PLANNING AMENDMENT

Application No. *H18/0227/02/A3*
 Date Registered **12 JUN 2002**
 Case Officer *T-G*

LAND OFF CHURCH GATE, SUPRA BRIDGE, LINCS

*ERECTION OF SEVEN HOUSES
 AND GARAGES.*

Site Layout

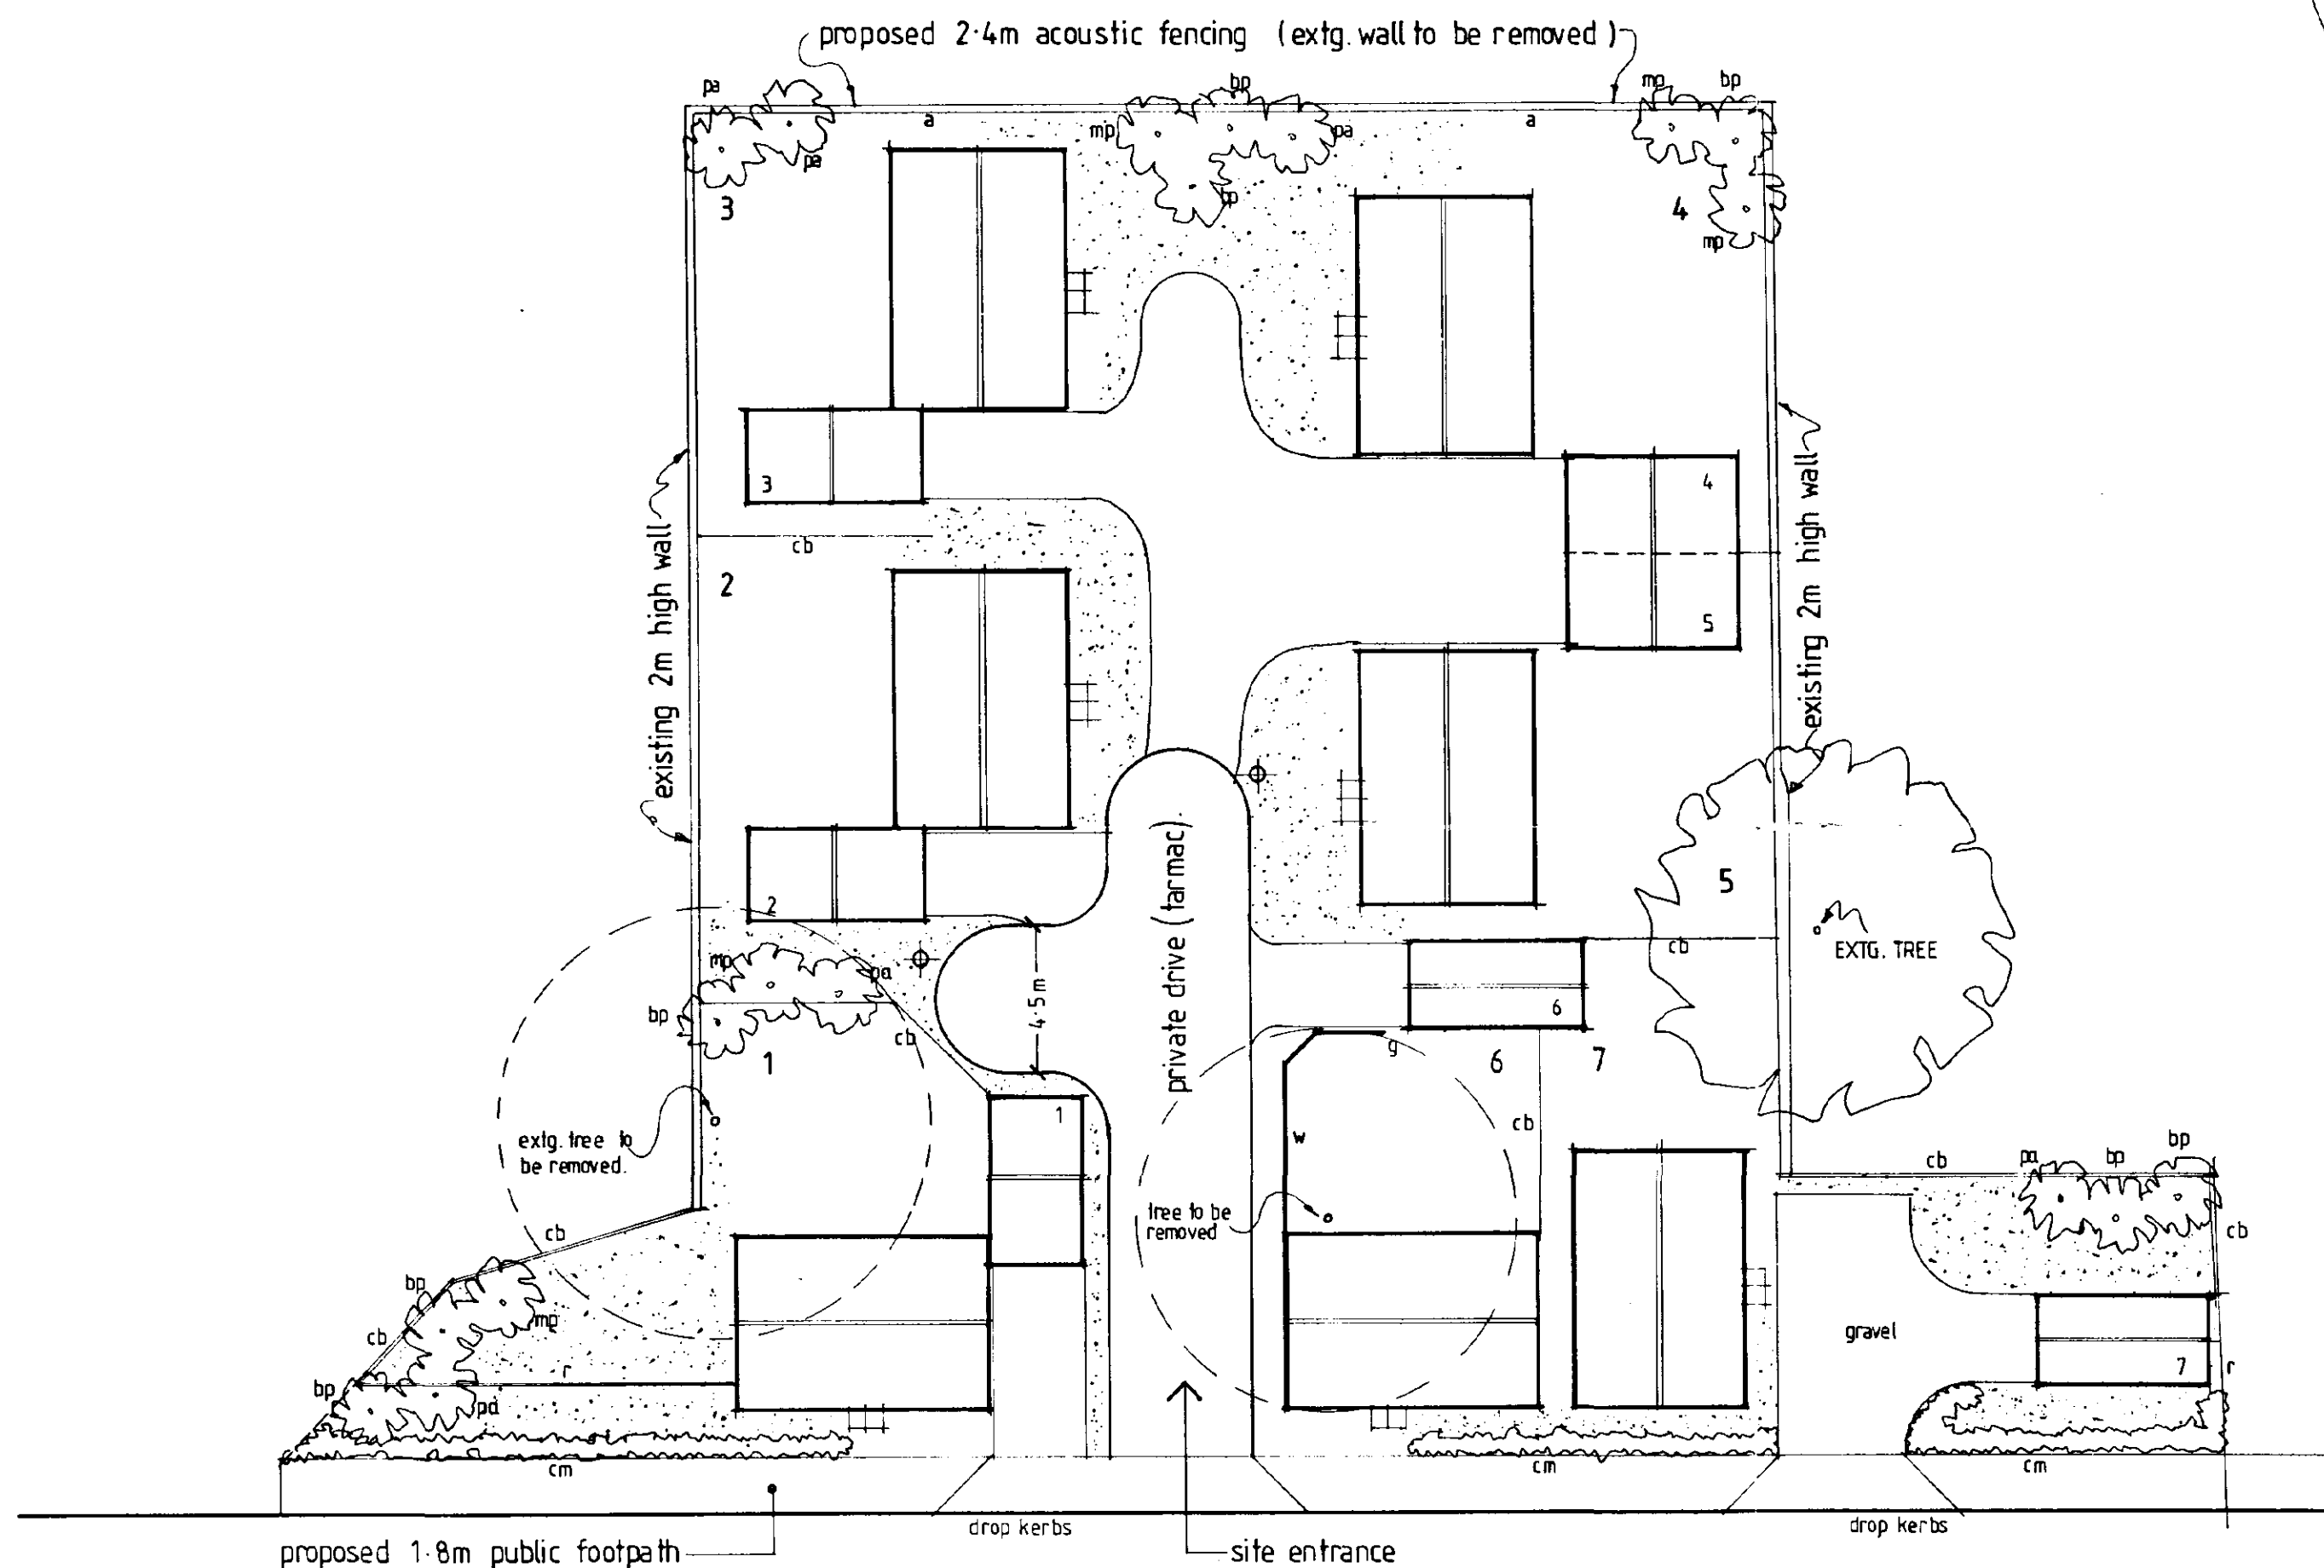
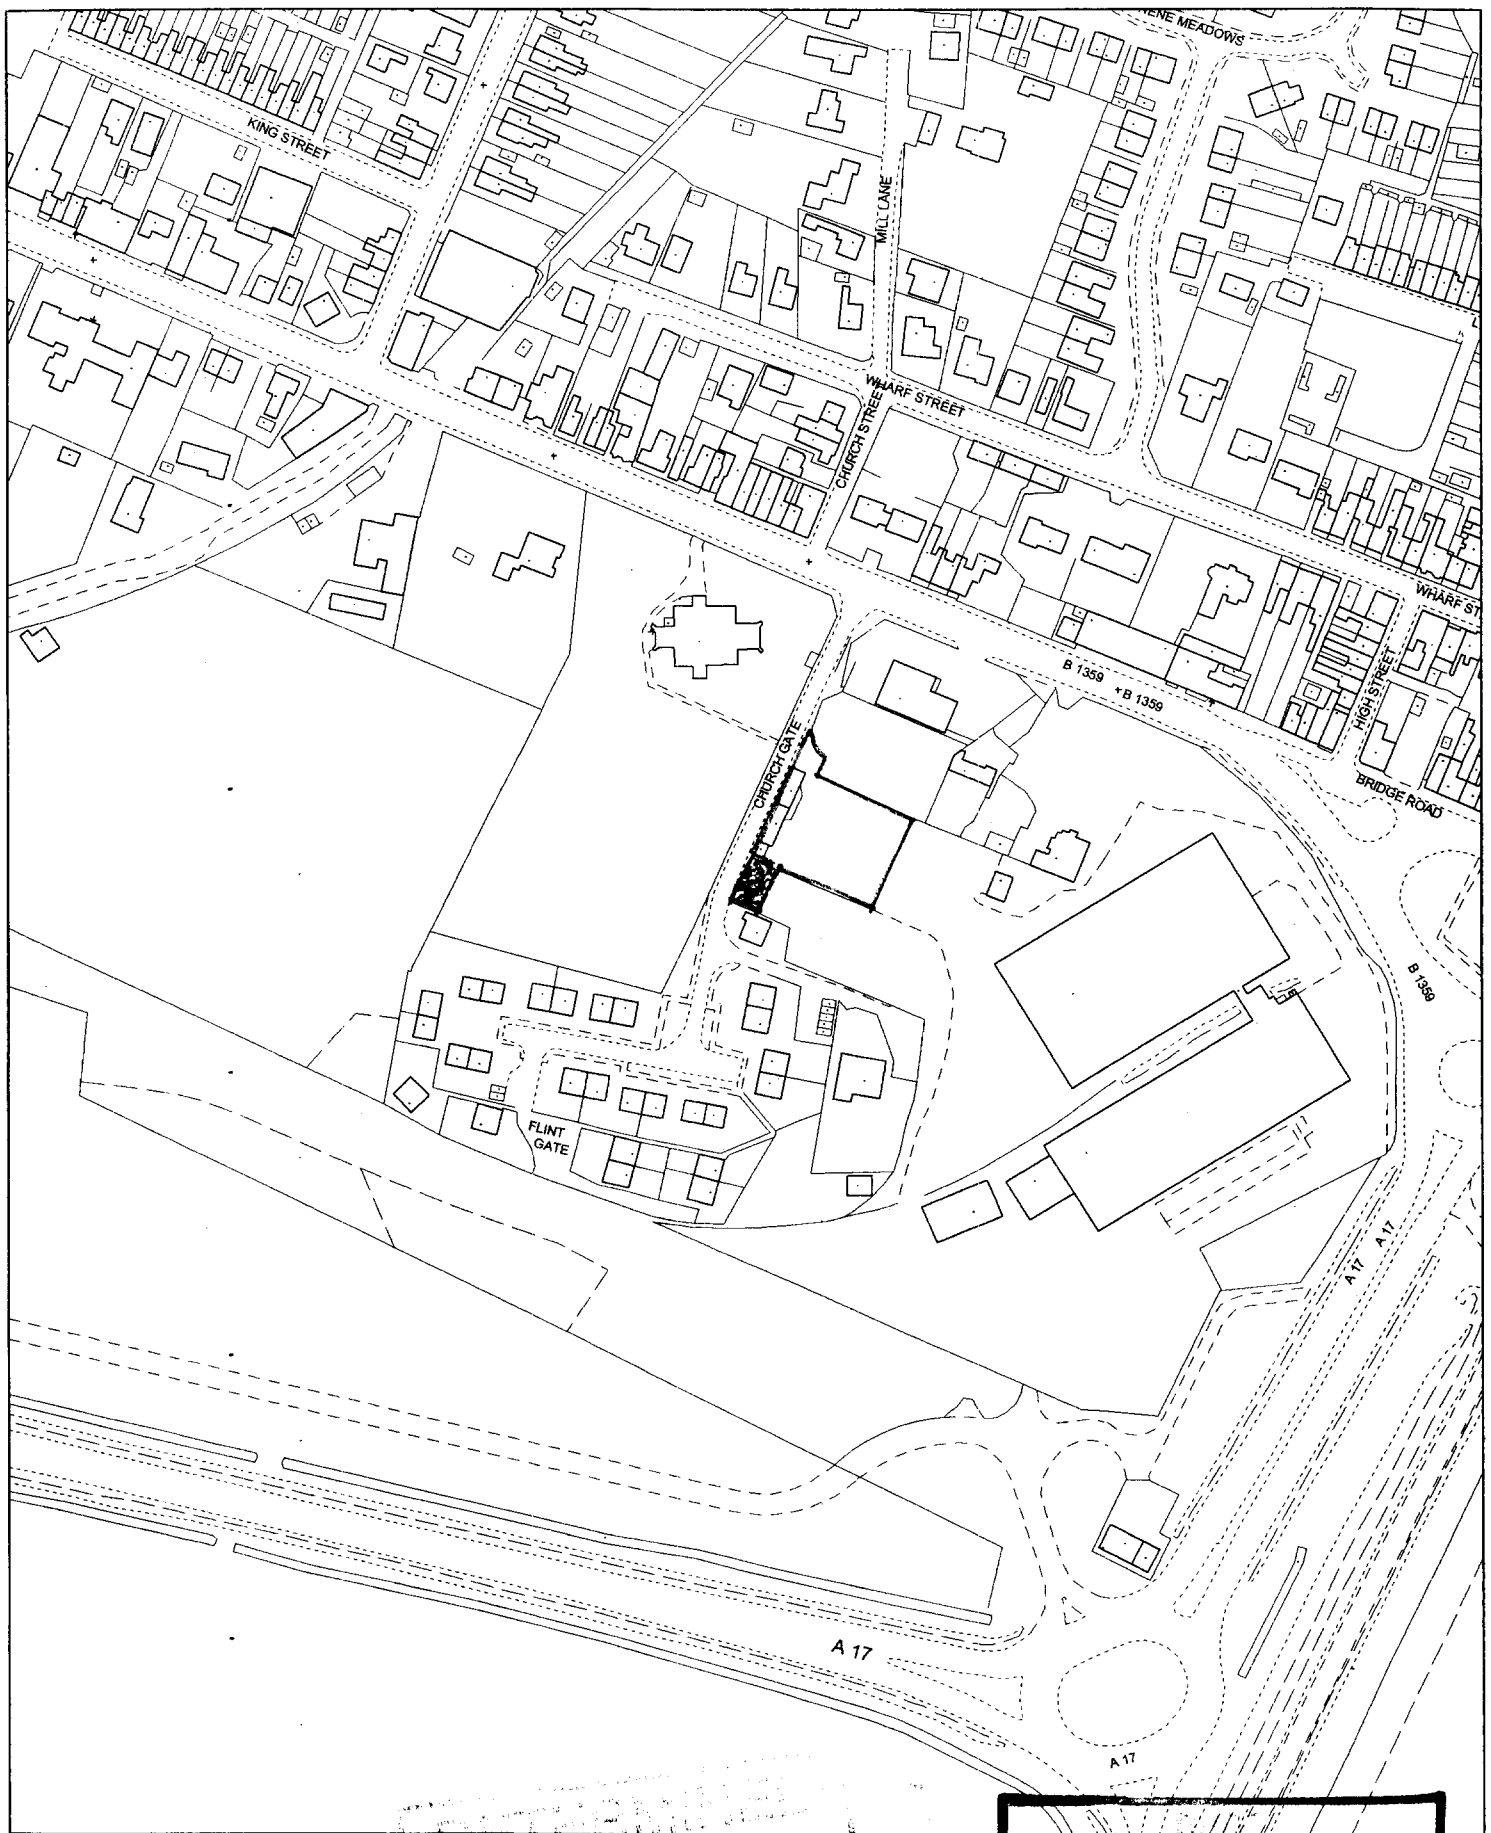
ALTERATIONS TO LAYOUT BY REDUCTION OF
1 DWELLING, RE-ALIGNMENT OF LAYOUT.
DESIGN ALTERATIONS TO ALL ELEVATIONS.
(AS DISCUSSED WITH D. GEDNEY 12.4.02).

PLOT 8 OMITTED.

PLOT 7
FLOOR PLANS & ELEVATIONS.

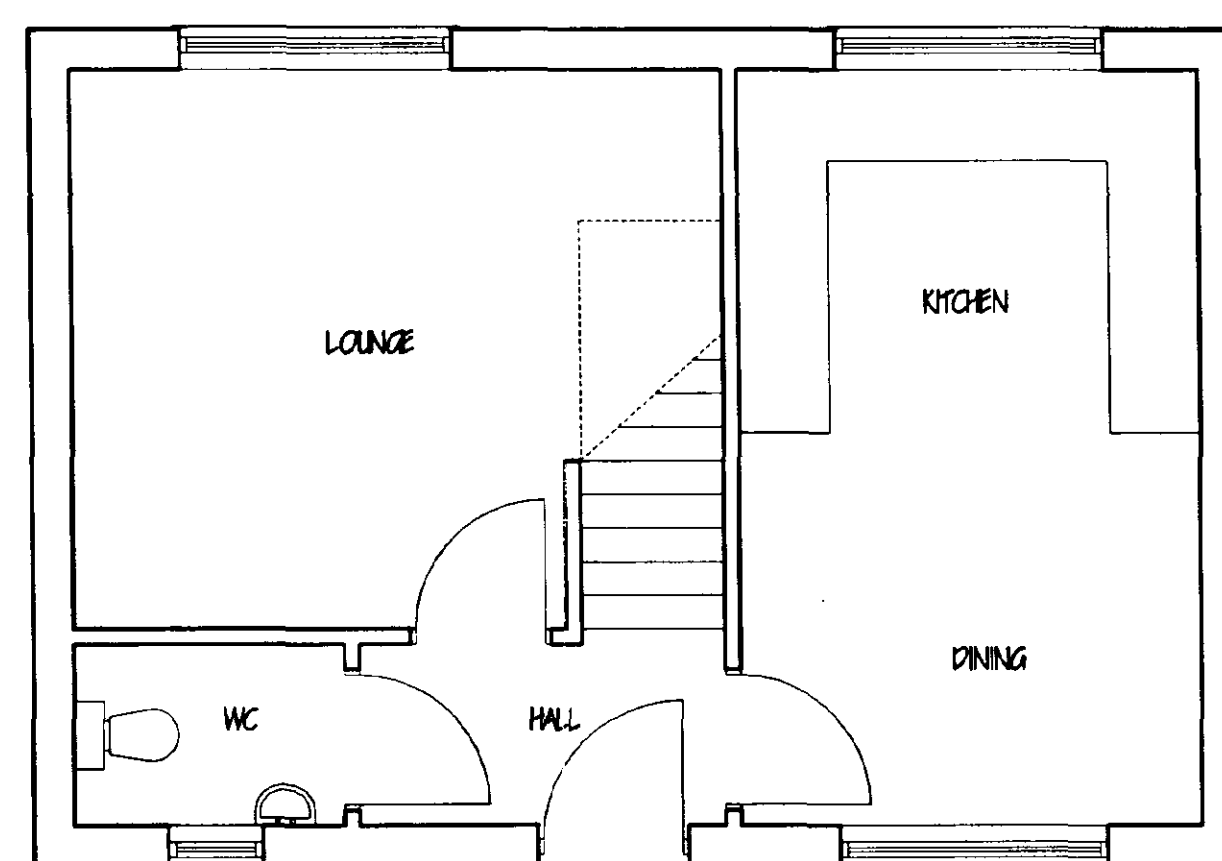
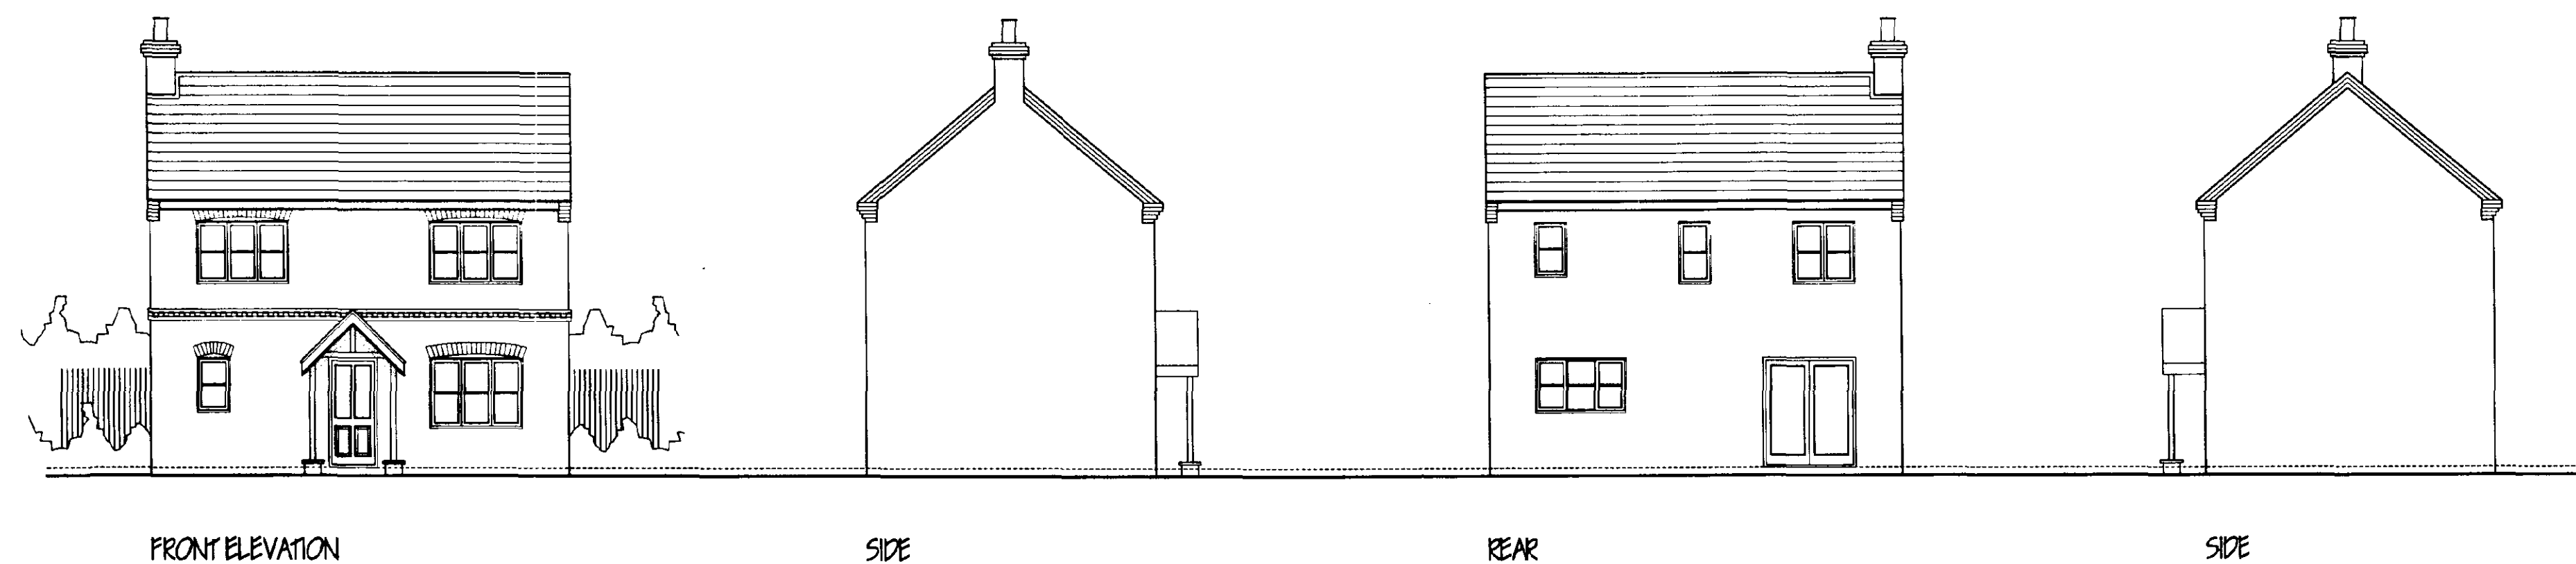
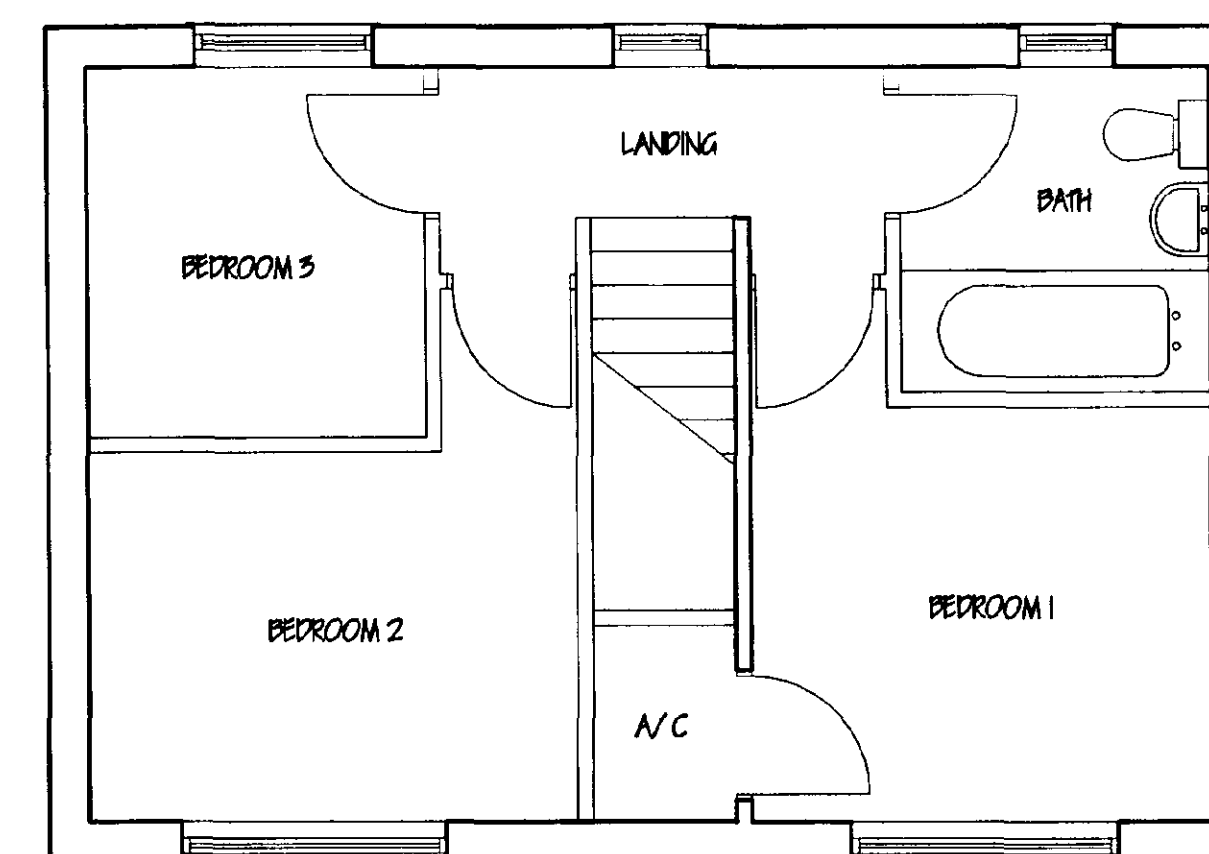
*DESIGN ALTERATIONS TO PLOT 7.
 (WINDOWS INCORPORATED TO SIDE ELEVATION
 AS DISCUSSED WITH P. GEDNEY ON 11.6.02).*

Amendment: Design alterations to Plot 7 - windows added to side
elevation (Dwg no.01.047/05B)
